Application Ref:	2024/0329	 Ribble Valley Borough Council www.ribblevalley.gov.uk		
Date Inspected:	02/07/2024		Site Notice:	N/A
Officer:	EP			
DELEGATED ITEM FILE REPORT:		REFUSAL

Development Description:	Demolition of existing garage and rear conservatory and construction of two-storey extension to side and single storey garden room to rear.
Site Address/Location:	15 Sabden Brook Court, Sabden BB7 9FY.

S J Bialecki
Drawing no 5006
Scale 1:100 & 1:50
Proposed Two Storey Extension At 15 Sabden Brook Court Sabden

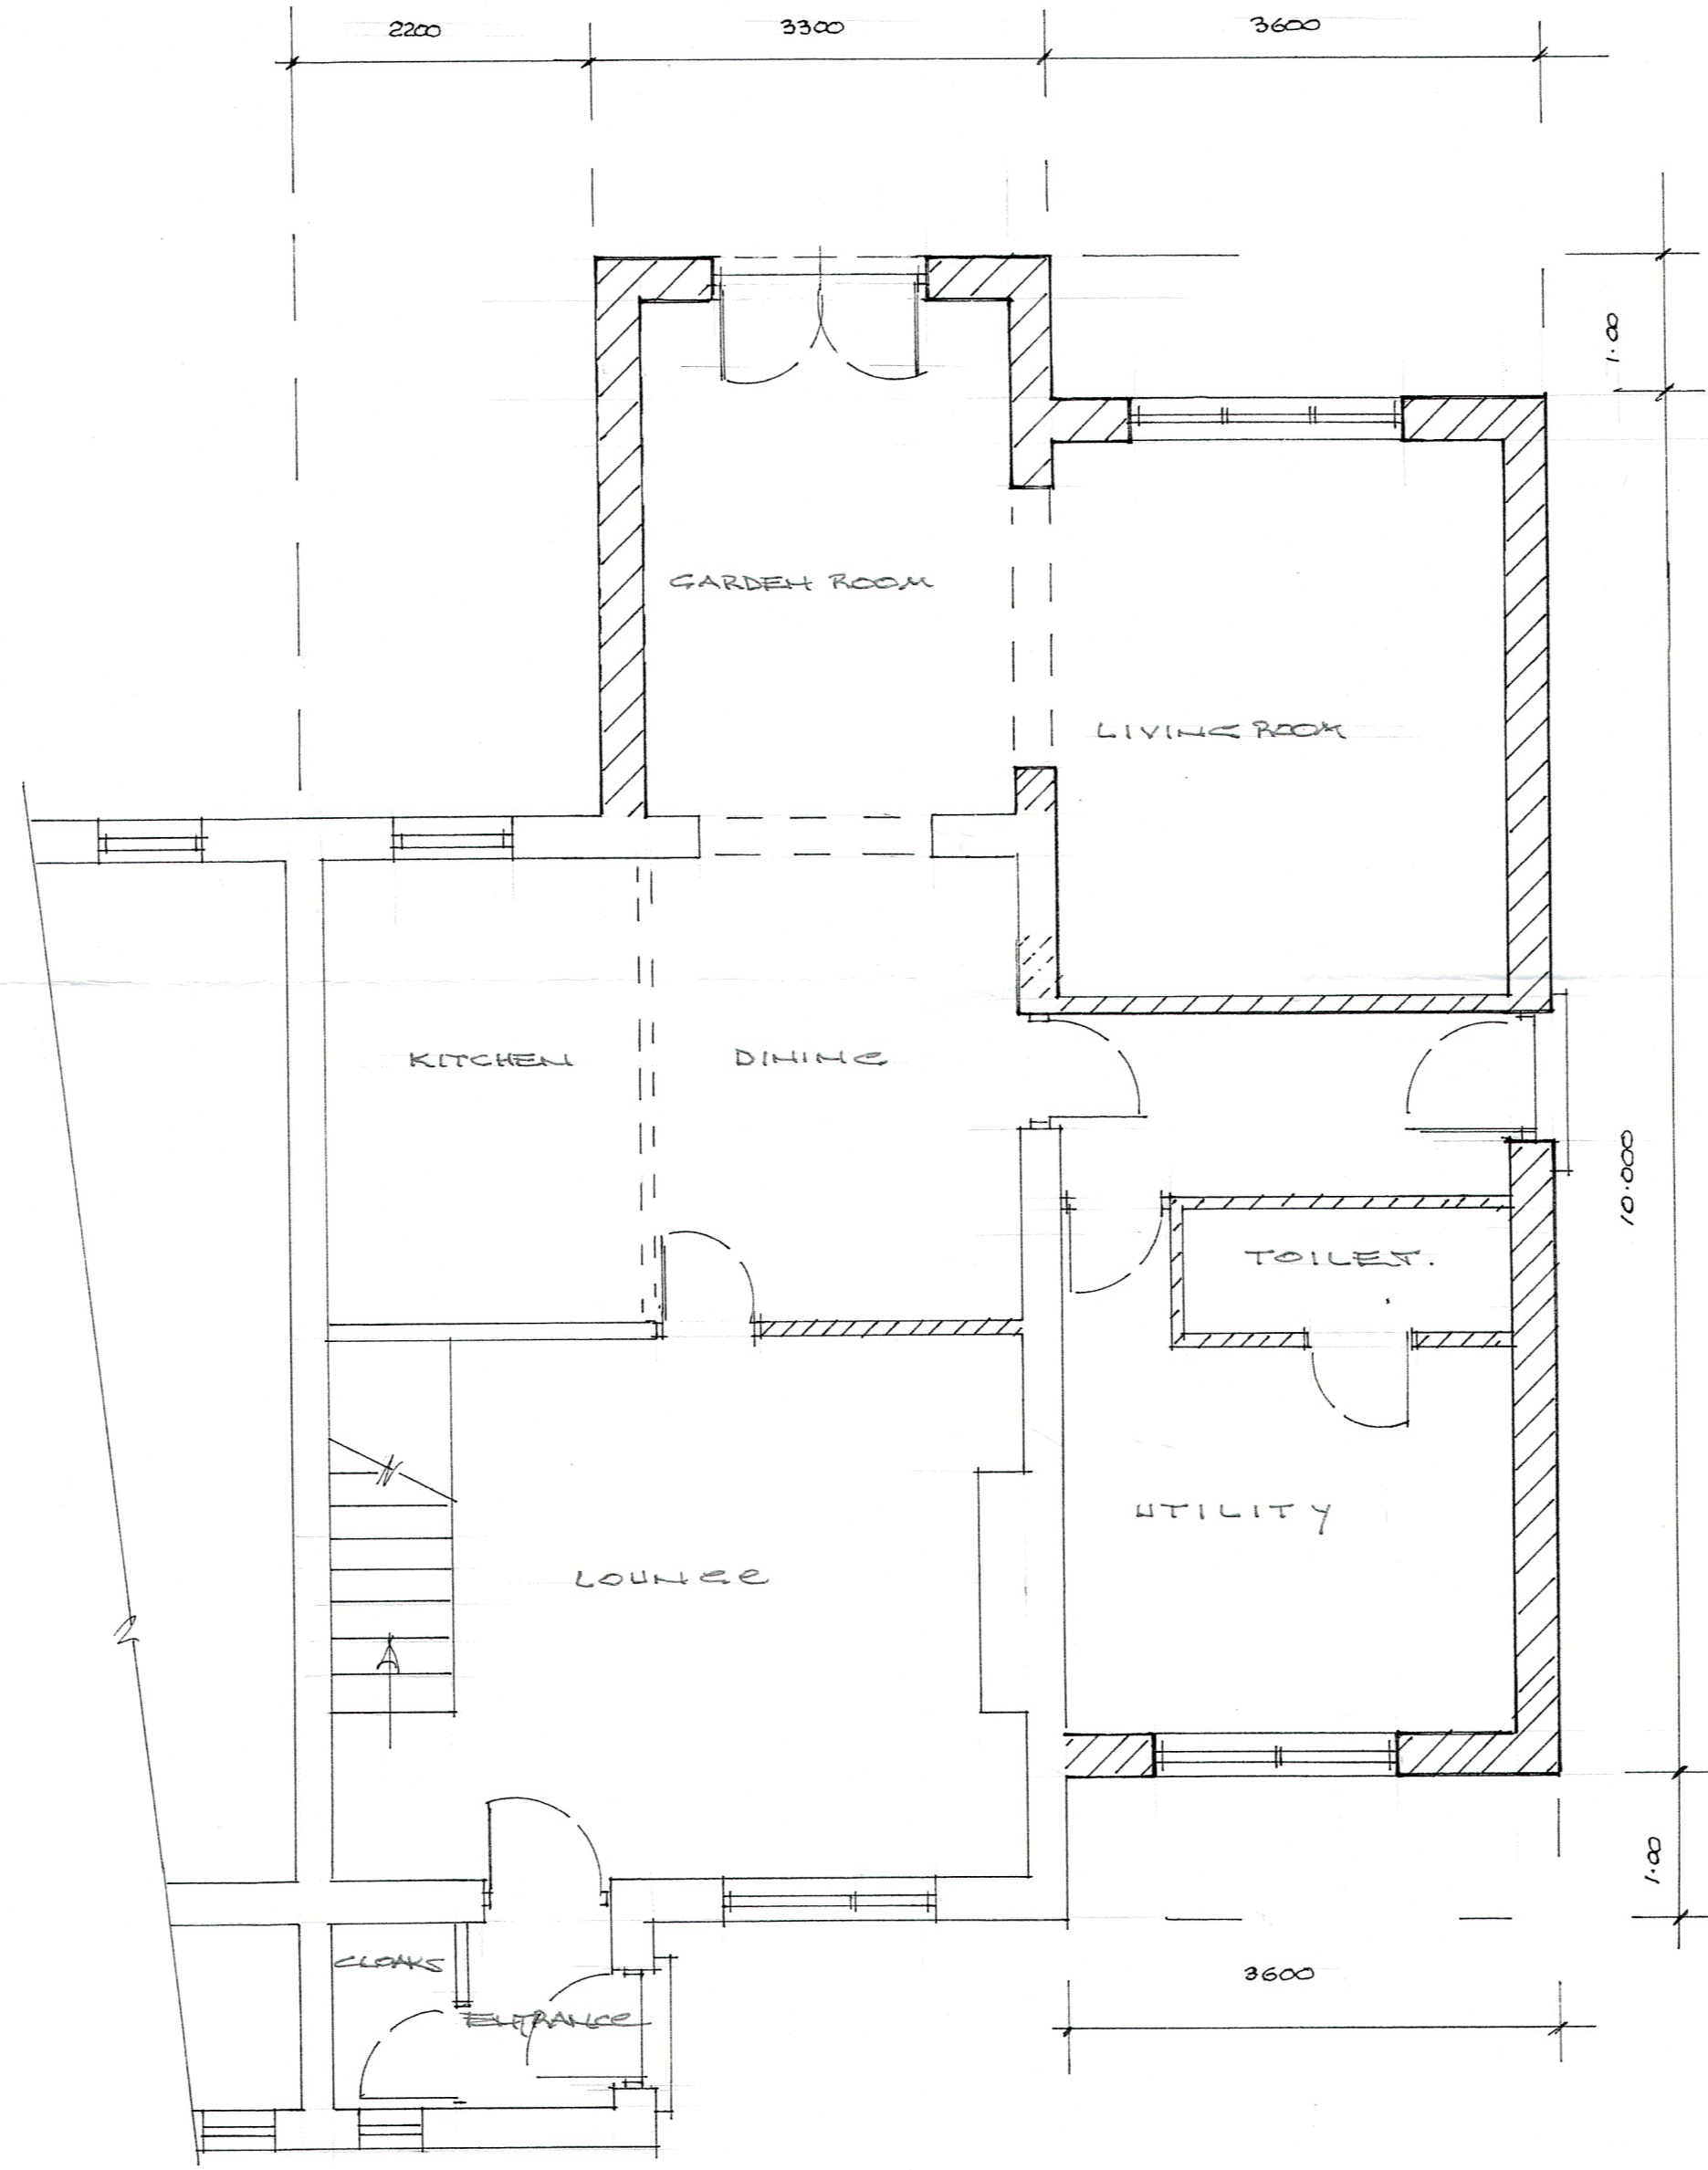
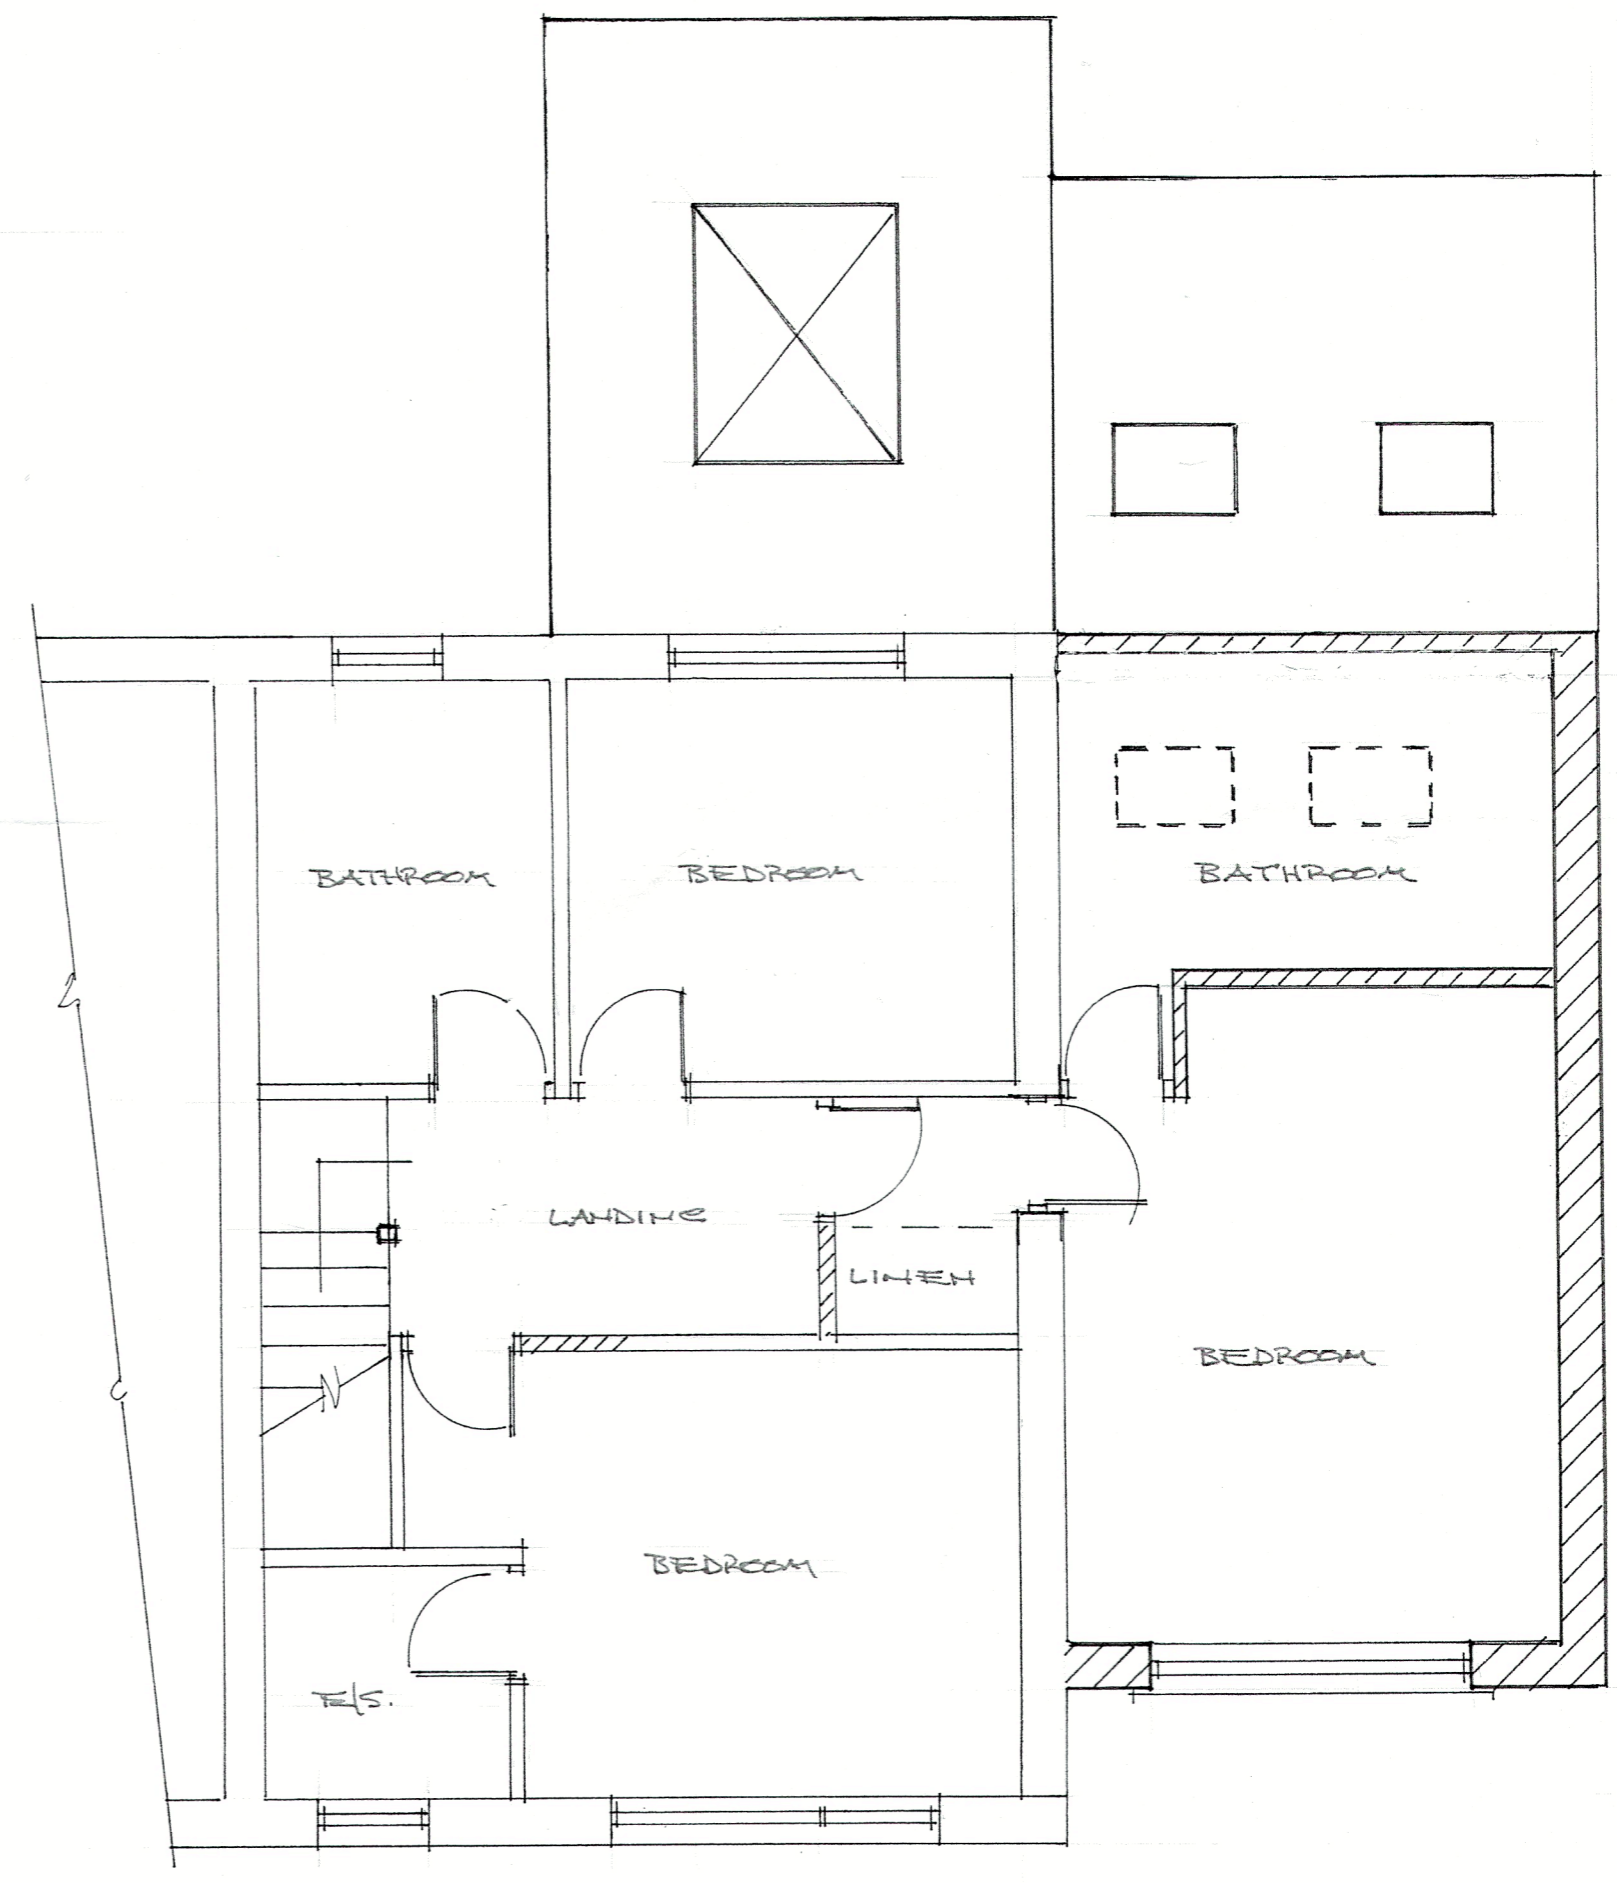
In respect of footprint, the proposed single storey rear and two-storey side extension will collectively increase the footprint of the original dwelling quite substantially. It is recognised that there is an existing conservatory to the rear of the dwelling to be demolished, but this does not appear to have received planning consent. Whilst this footprint increase alone would likely have been acceptable, paired with the exaggerated roof slope, the extension would dominate and detract from the original dwelling, failing to take a subservient position.
